**RE: PROJECT ADDRESS – SWC OF NM 528 & ELLISON – ALBUQUERQUE, NM.  
87114**

**ADMINISTRATIVE AMENDMENT TO OVERALL SITE PLAN FOR BUILDING PERMIT**

## Administrative Amendment Request

Transportation Development Comments:

1 SITE PLAN
SCALE: 1" = 50'

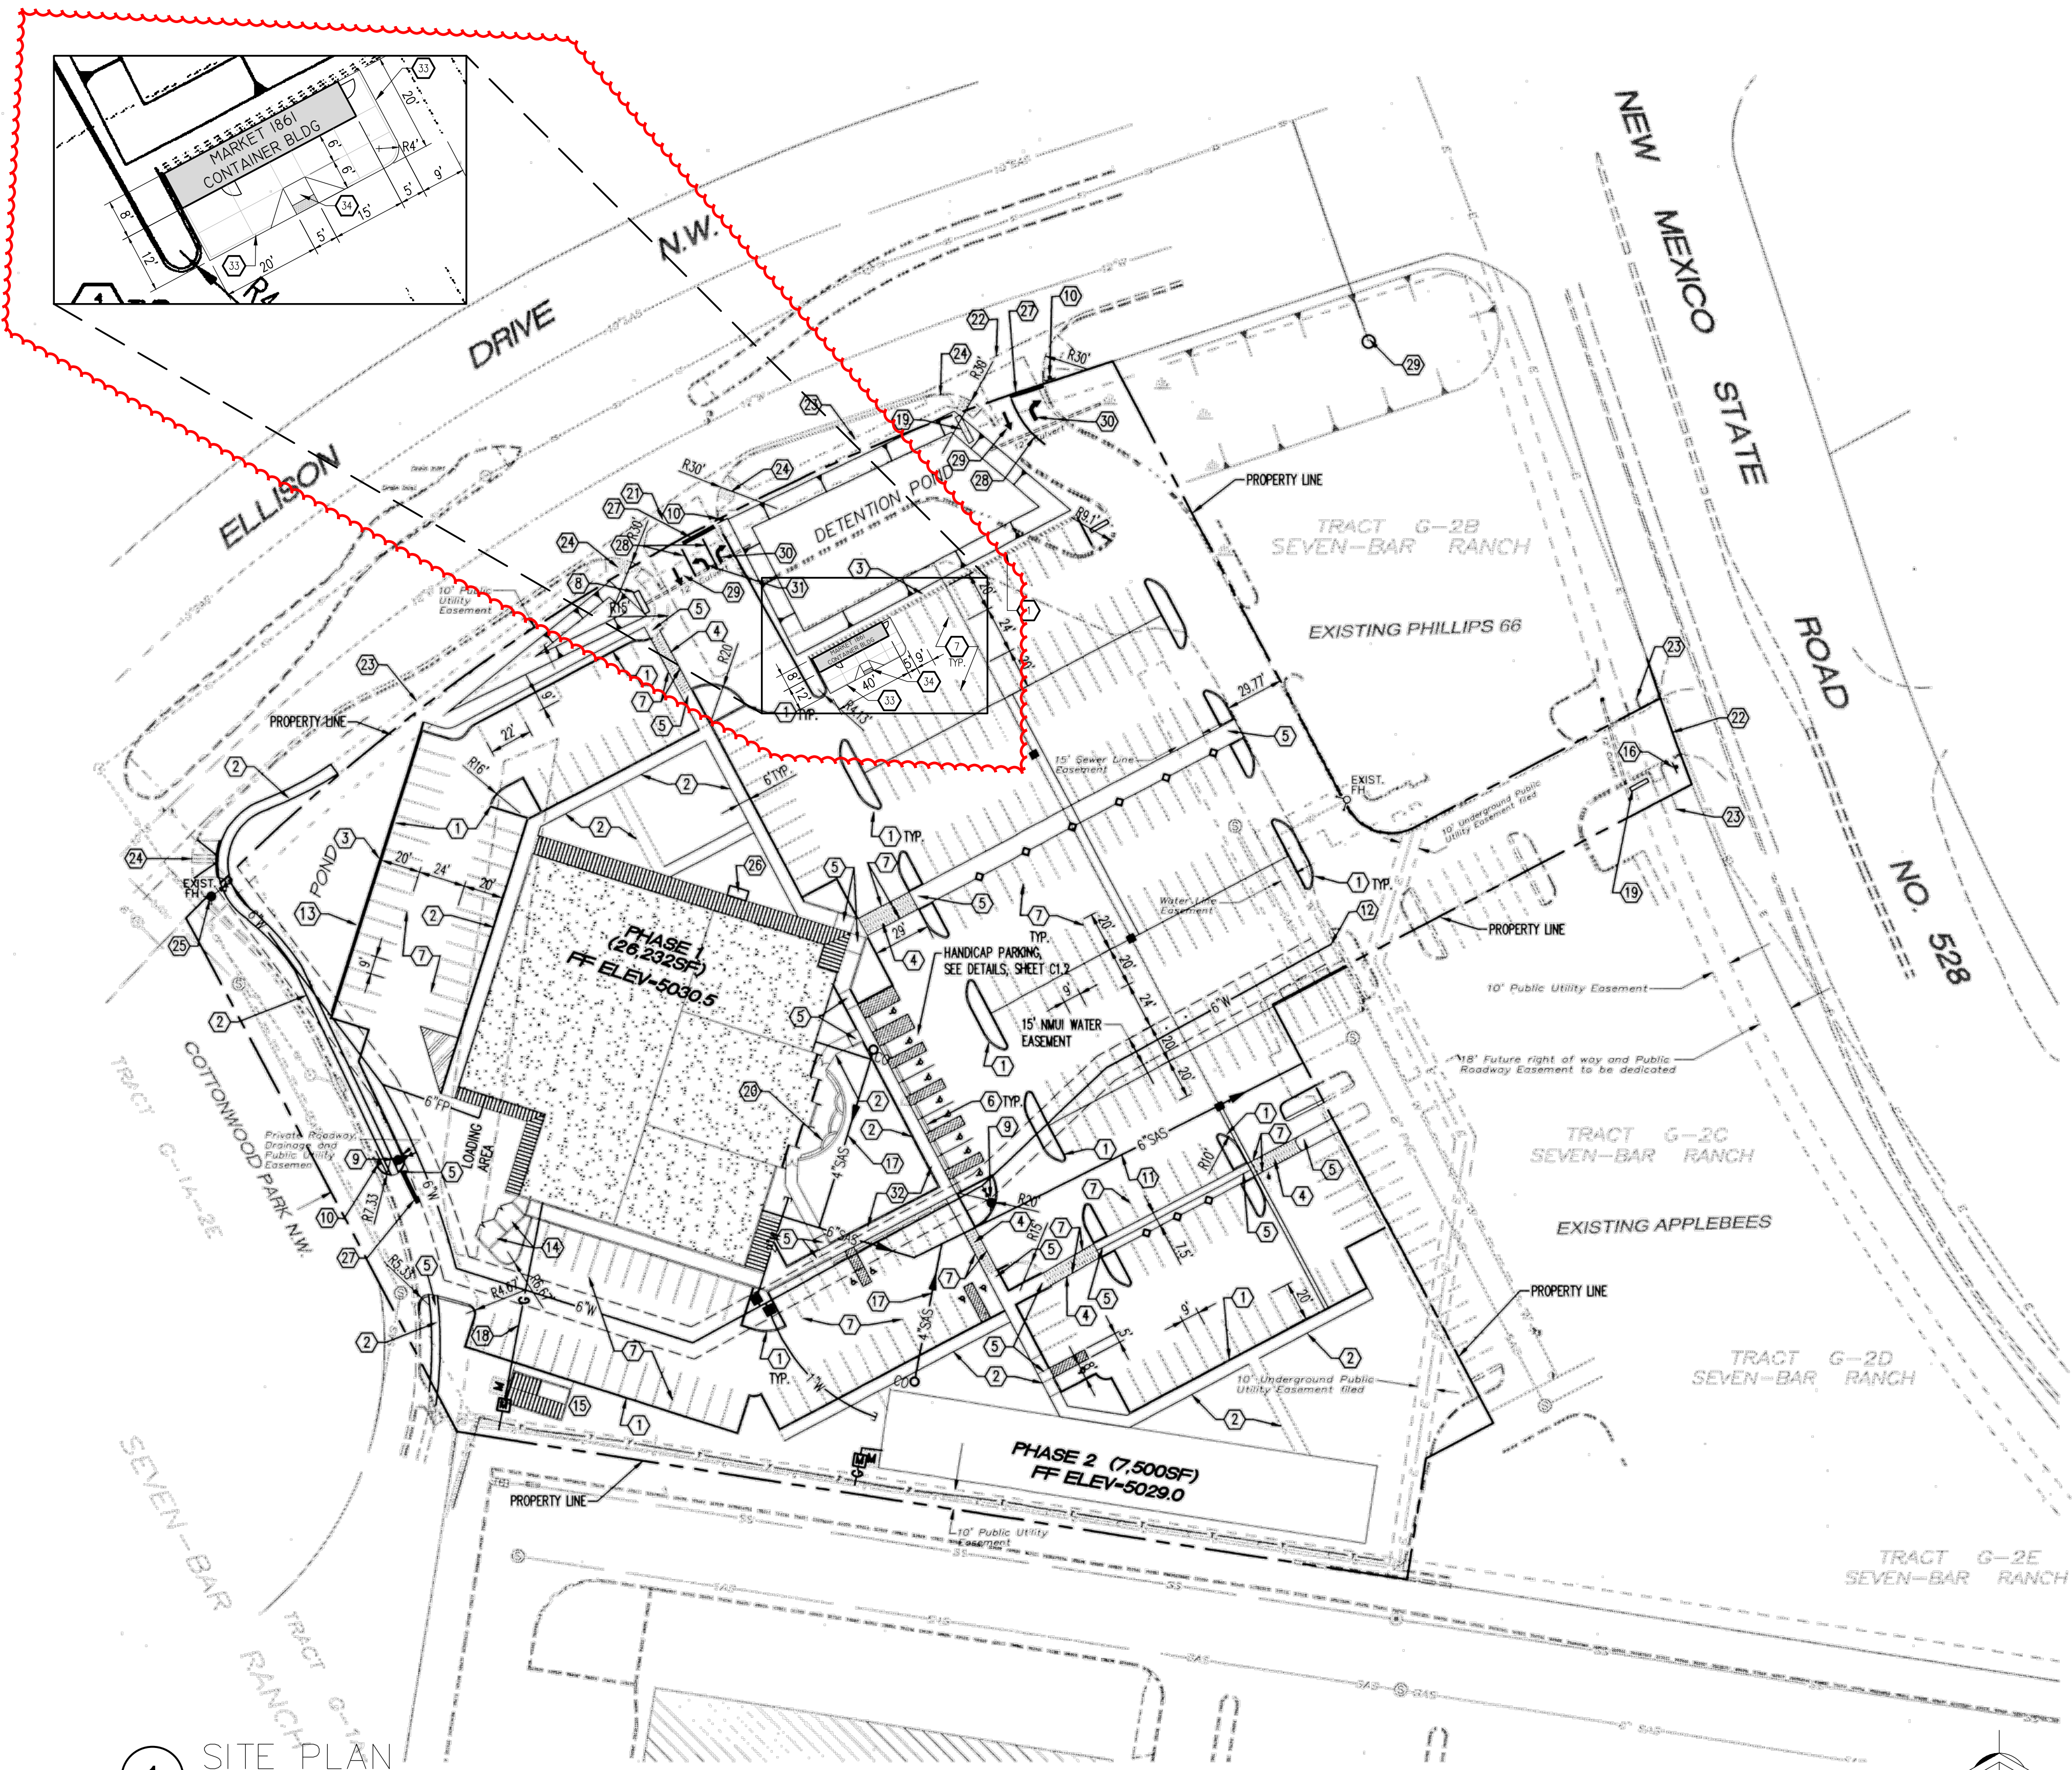
- Please explain why you are proposing concrete stoop and concrete landing.
  - Addressed:
    - The concrete around the kiosk is used to level the asphalt with the kiosk. The kiosk does not fit level on the asphalt.
- Provide details for the proposed concrete landing and concrete stoop.
  - Addressed:
    - Please see details on A-2.
